From: Nik Weaver on behalf of Planning.Responses
Sent: 18 August 2022 15:10
To: Planning Scanning
Subject: FW: A/43/22/PL.

Subject: A/43/22/PL.

Drawing title
Landscape General Arrangement Plan

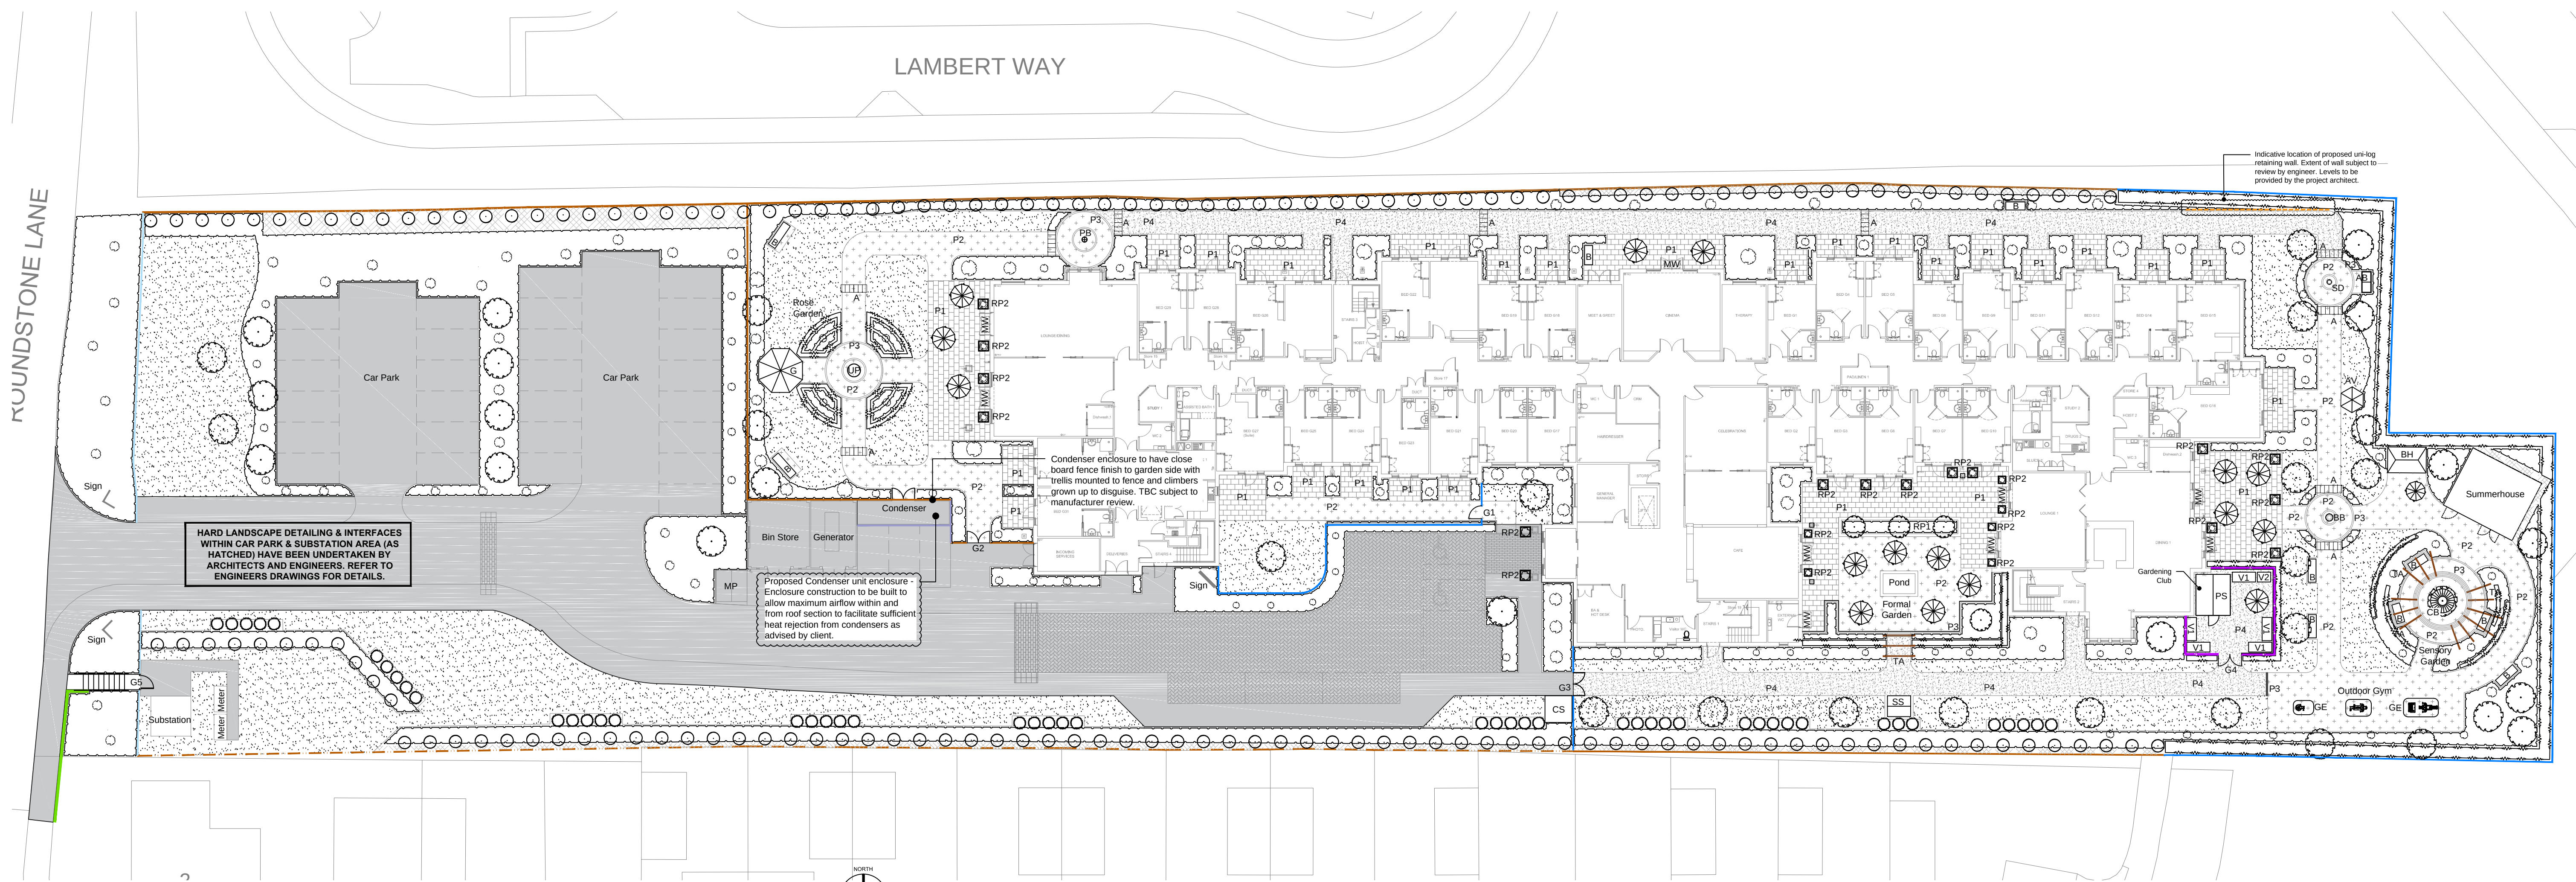
I have now had an opportunity to discuss the application with my Team Leader, Juan Baeza and he agrees that the items detailed in my e-mails below namely bbq hut, summerhouse, hoop top fencing and removal of TPOd trees should be deleted from the application if it is to be recommended for approval by officers.

Further to our emails last week, I can advise the applicant is instructing architects and landscaping consultant to submit amended drawings to address your comments regarding summerhouse, bbq, and trees. I'll update you when the amended plans are likely to be submitted to you. We are hopeful they can be submitted soon.
